Application No: FG/46/21/PL
Site Address: Land between 11a The Grove and 30 Brook Lane Ferring
Description of works: Development of 1 no. 2 bed house set over 2 floors, with first floor being partially contained within roof, along with associated parking & amenity spaces. This site is within CIL Zone 4 and is CIL liable as new dwelling.

Thank you for your internet representation made on 20th April 2021 which has been recorded as an objection with the comments as follows:

Drawing Title 028_02 Proposed Ground Floor Plan Land between 11A The Grove and 30 Brook Lane, Ferring					
Completion date 17/03/2021					
Drawn by Guy Rochez ARB					
Scale: 1:100@A3					
Print Size: A3					
Notes:

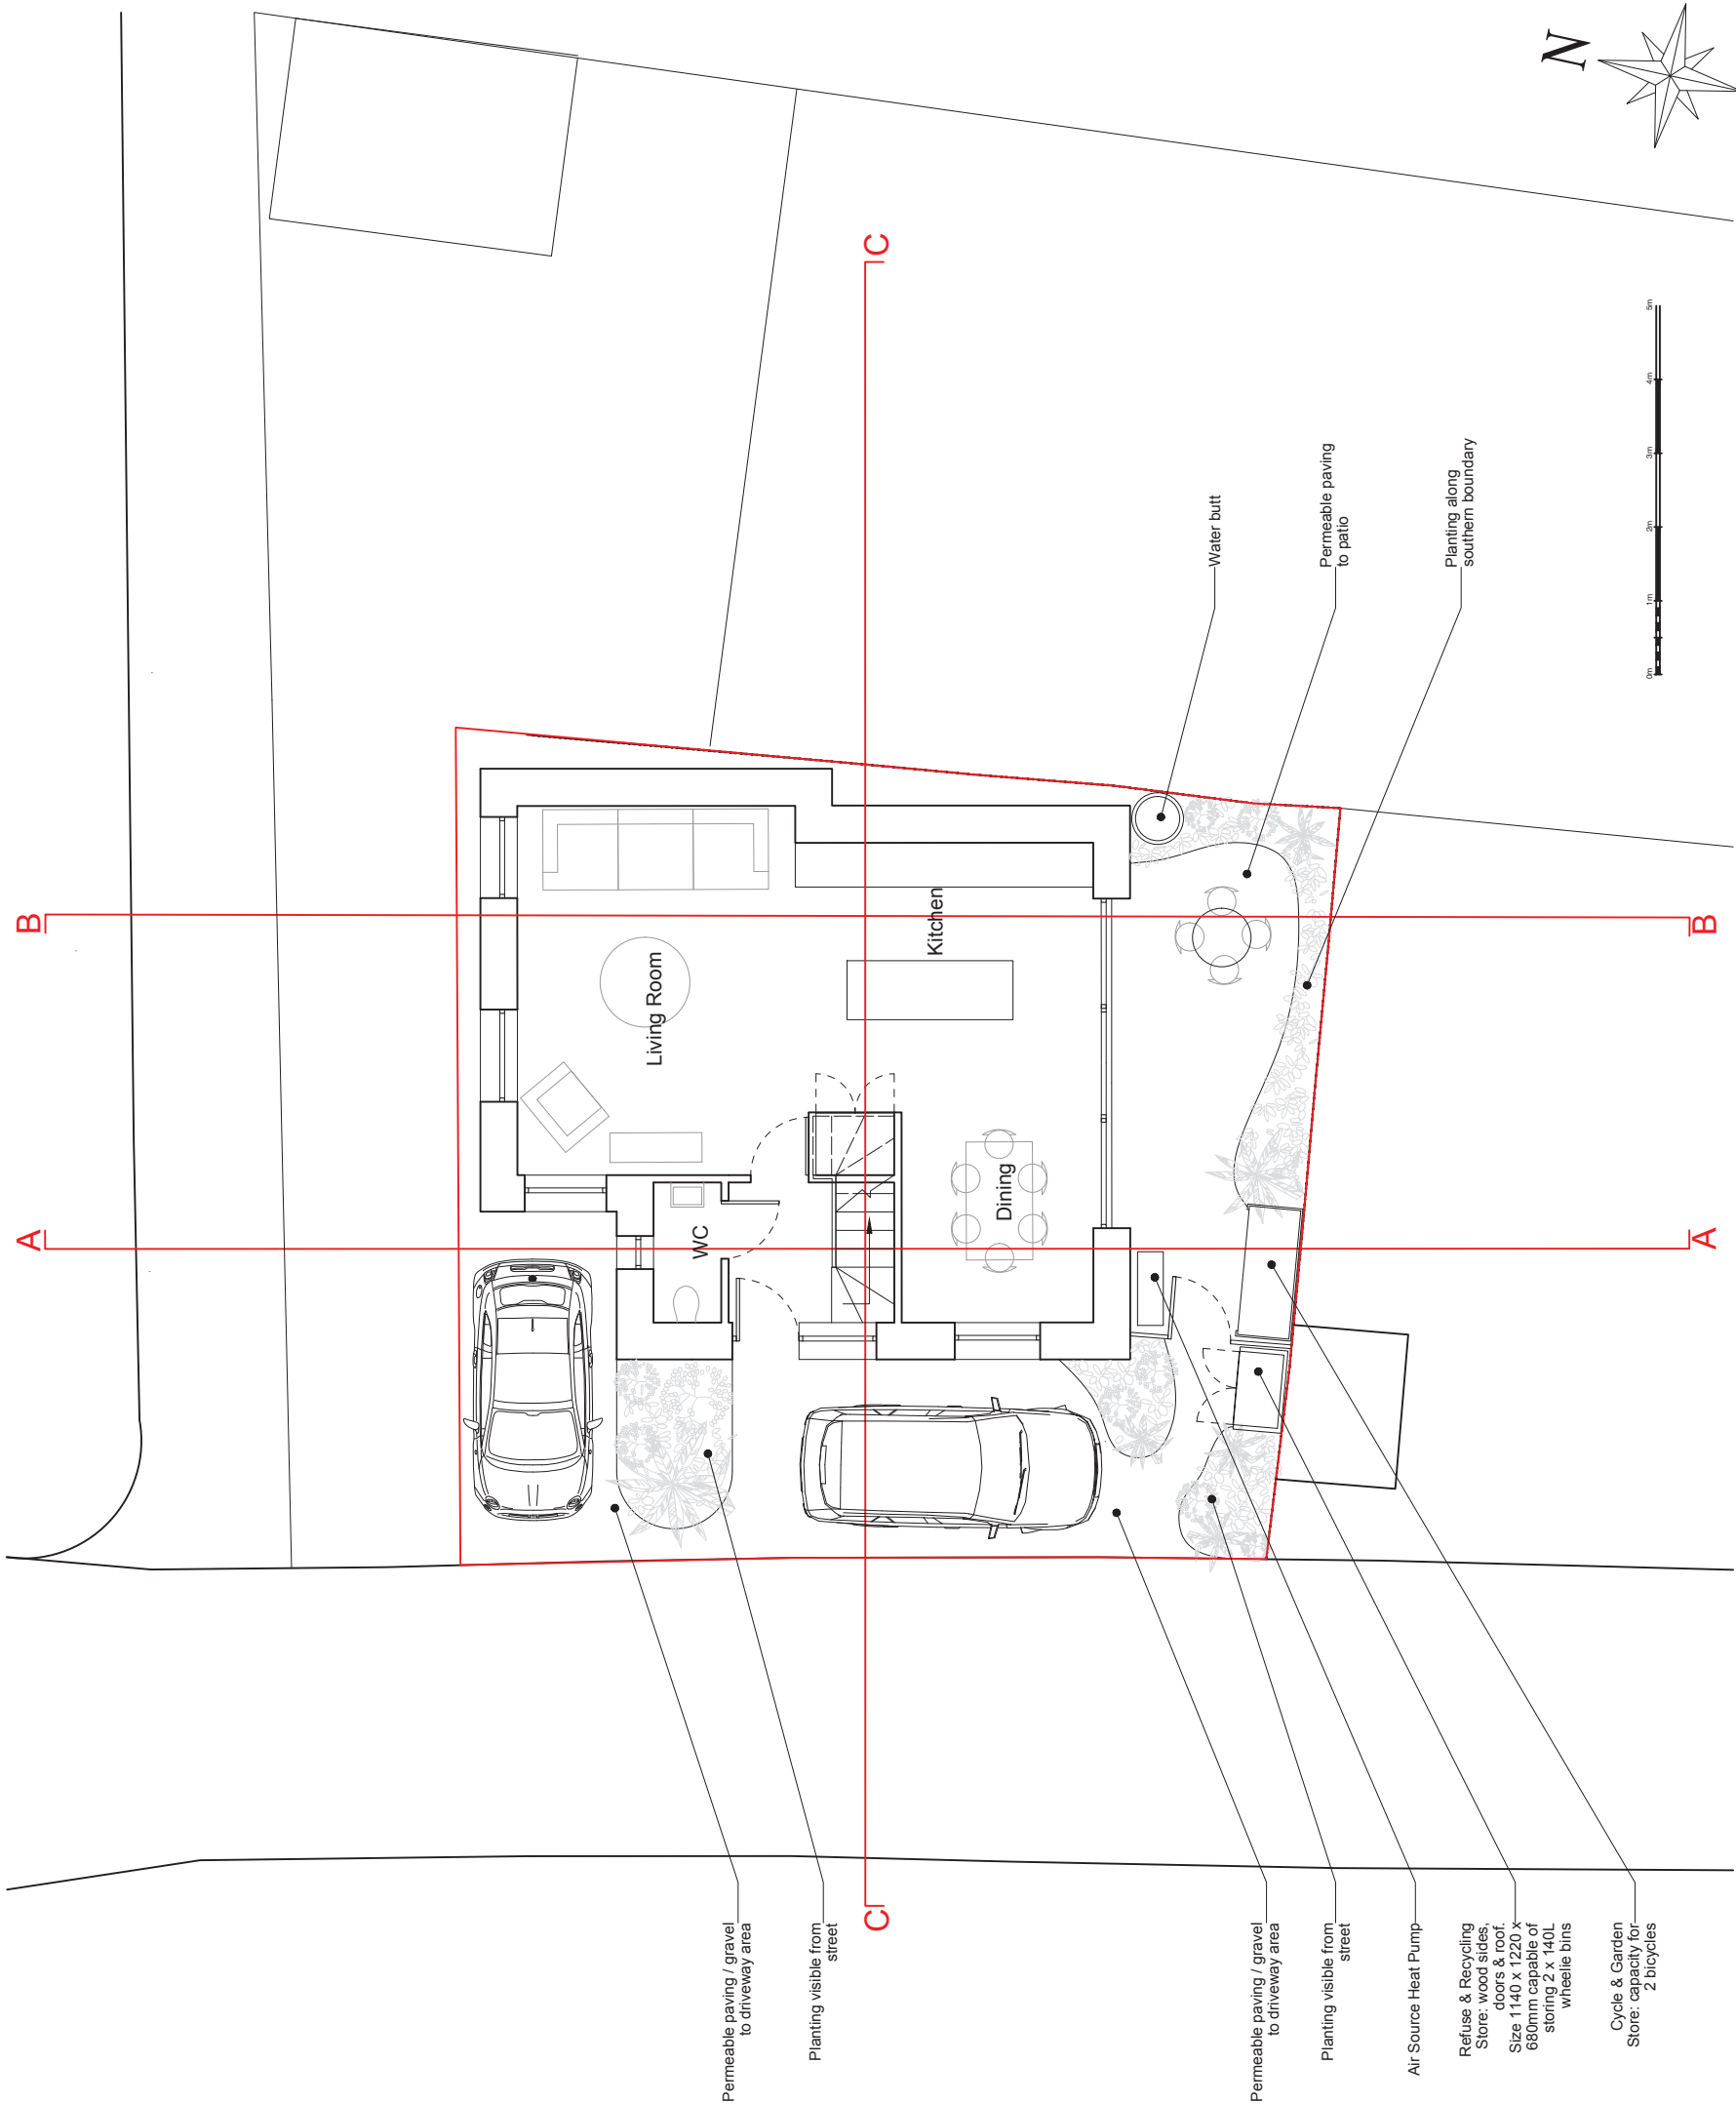
Of primary concern is the eastern elevation where the dwelling appears to extend tight to the boundary with no access available to maintain the building without incursion over the neighbouring private garden. This will clearly raise issues for future residents of the proposed new property and also potentially for neighbour disputes over access. Such elements are to be avoided in new building design.

This, together with inadequate parking and outside amenity space appropriate for a two double-bedroom detached residence, demonstrates that the size and footprint of this proposed dwelling cannot be accommodated within the confines of the small plot available.
